State of Washington  
**DEPARTMENT OF FISH AND WILDLIFE**

**RE: WDFW comments on SP-24-00001 4G Farms Short Plat**

Thank you for the opportunity to comment on the proposed short plat (SP-24-00001 4G Farms) to divide the existing parcel into two lots. The Washington Department of Fish and Wildlife (WDFW) has reviewed the application materials and WDFW is primarily concerned about the identification and protection of critical areas on or near the project site and how they may be impacted by future development.

WALKER DRIVE SHORT PLAT
 PART OF SECTION 32,
 T. 18 N., R. 19 E., W.M.
 KITTITAS COUNTY, WASHINGTON

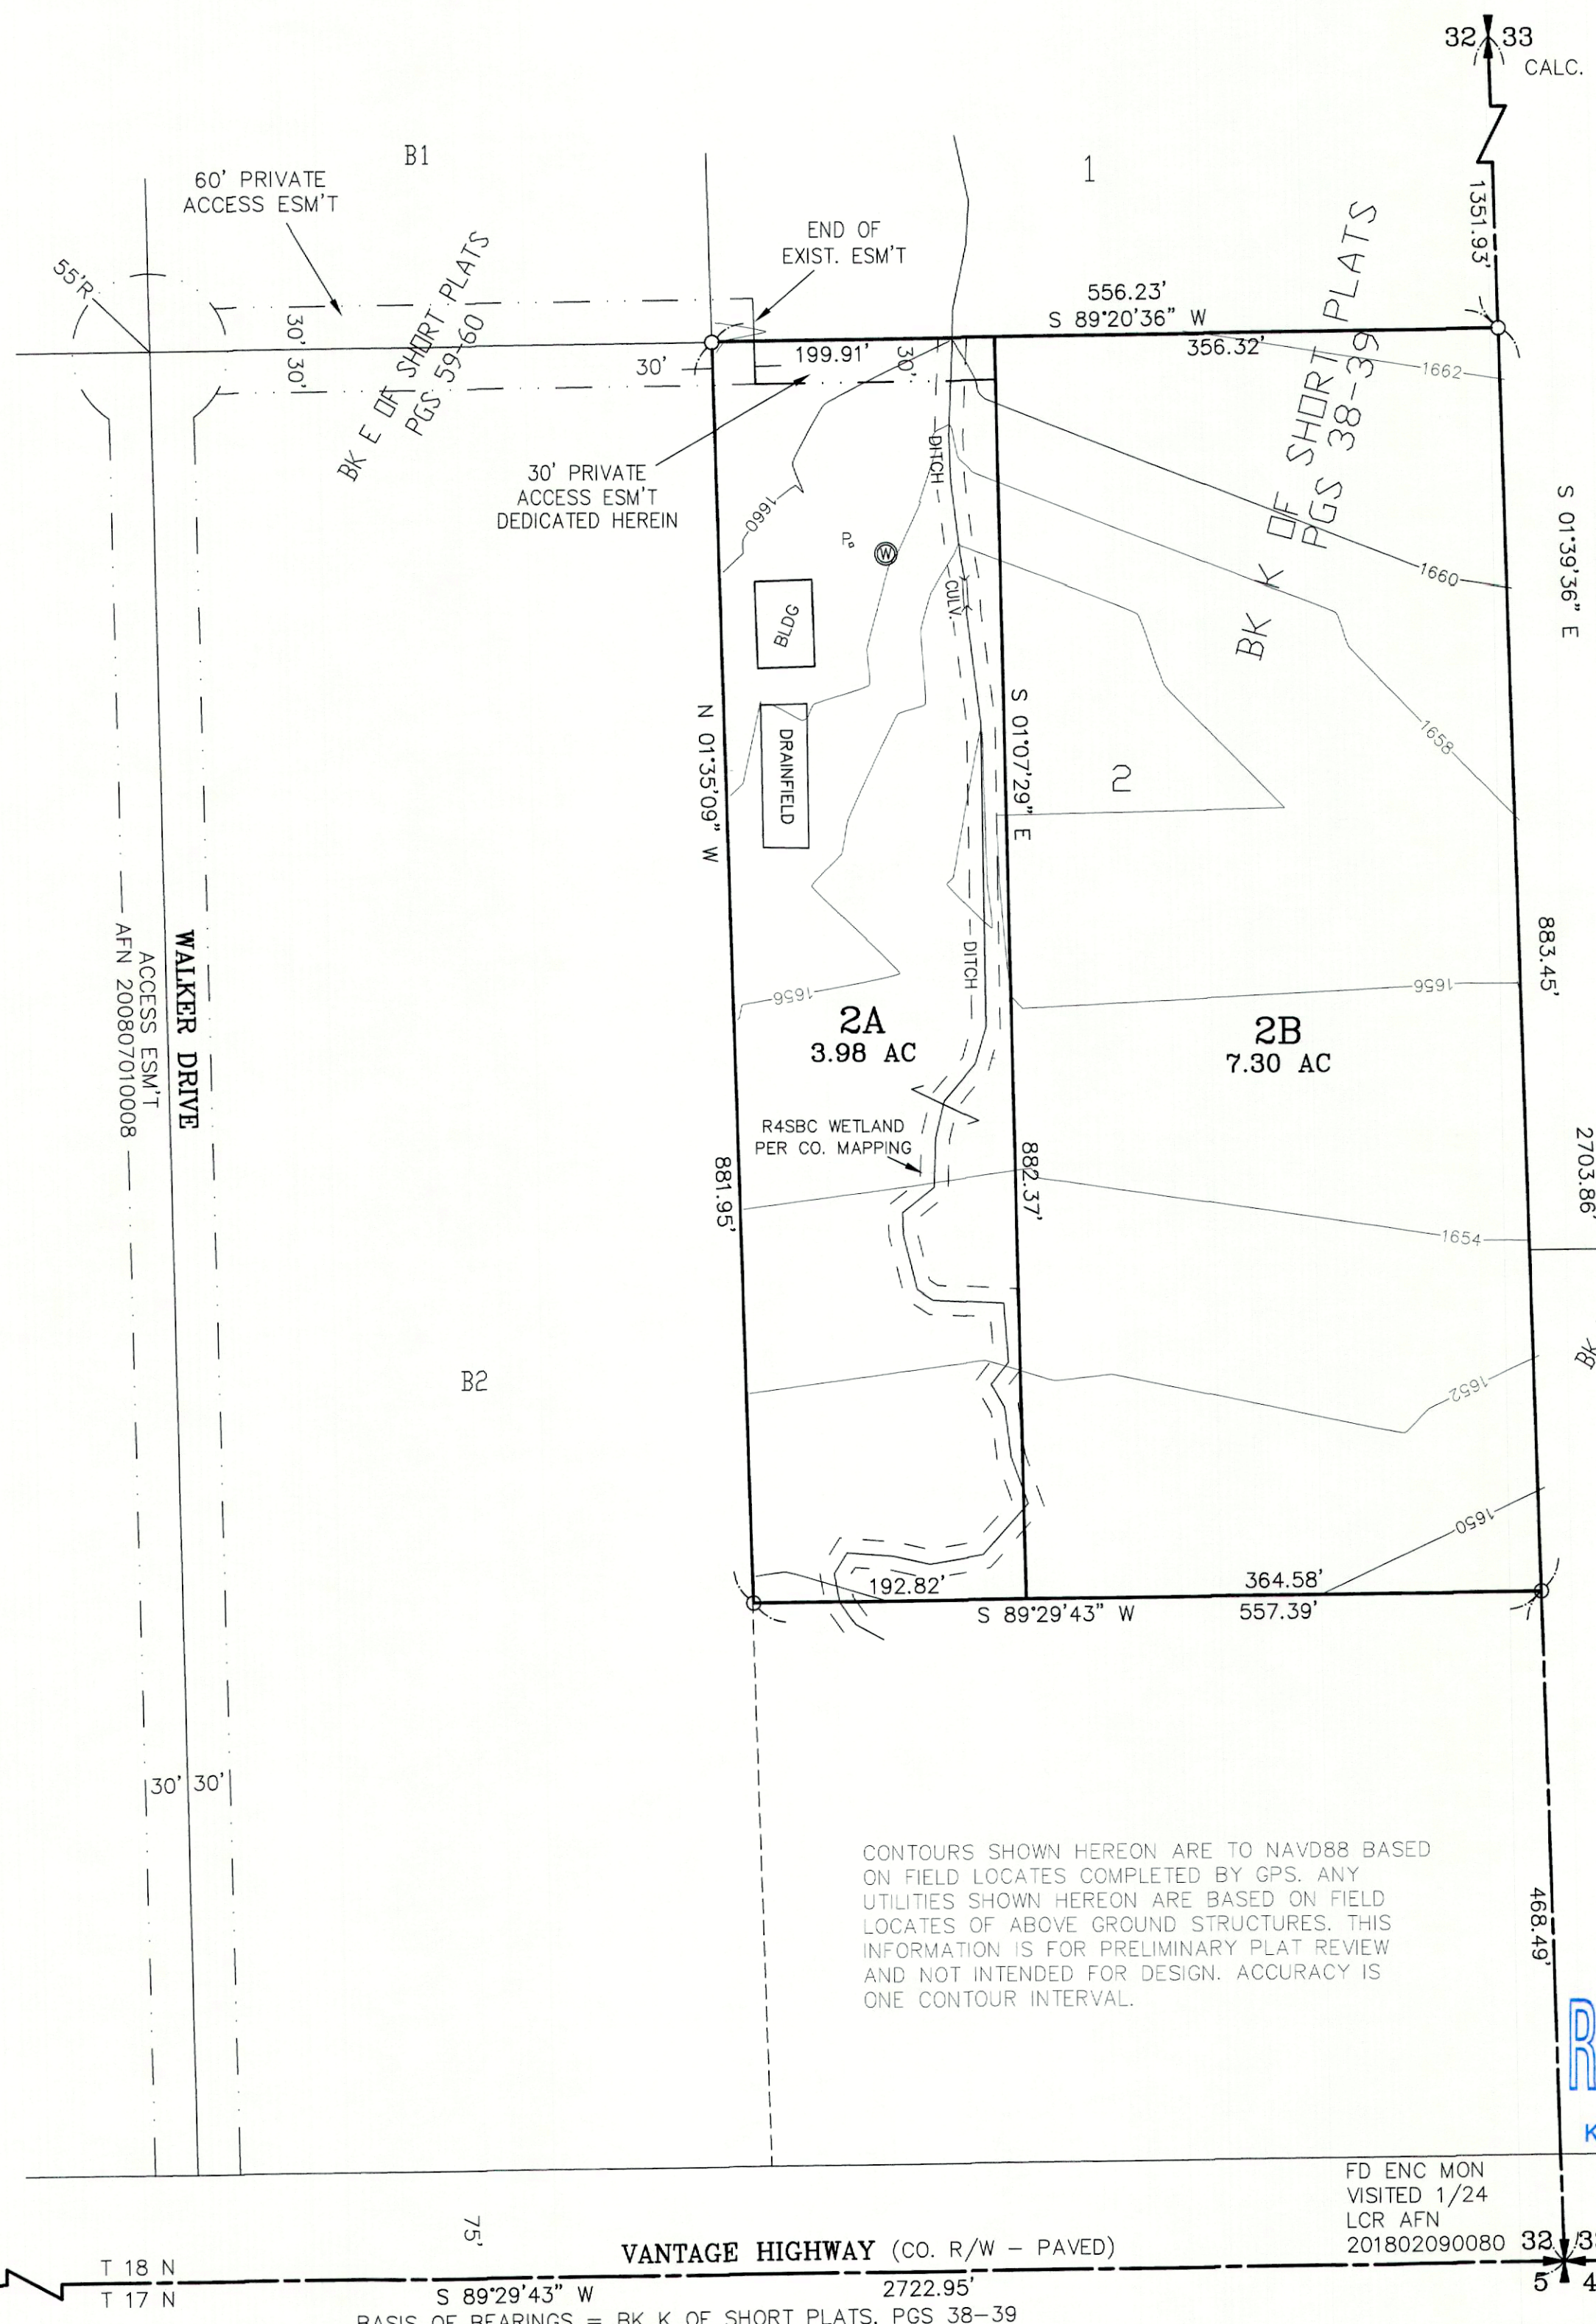
Mapping produced during the County's [Wilson-Naneum-Cherry Assessment](#) show Little Naneum Creek originating north of the project area and Cascade Canal, and flowing southerly through the property and called out in the preliminary short plat map as "Ditch", near the proposed new parcel boundary. Little Naneum Creek is a distributary channel west of the mainstem Naneum Creek. Little Naneum Creek flows year-round through most of its length and is a fish bearing stream. Ensuring Little Naneum Creek is correctly identified as a fish bearing stream in this short plat process will protect the functions and values of this important critical area.

As part of the short plat process, future building and septic locations for new parcels should be considered such that the critical areas can be protected along with future infrastructure without the need for future variances from the critical areas regulations. We appreciate the opportunity to comment and work with the proponents to meet their needs. Please feel free to contact me at (509) 961-6639 or [Jennifer.nelson@dfw.wa.gov](mailto:Jennifer.nelson@dfw.wa.gov) if you have any questions about these comments.
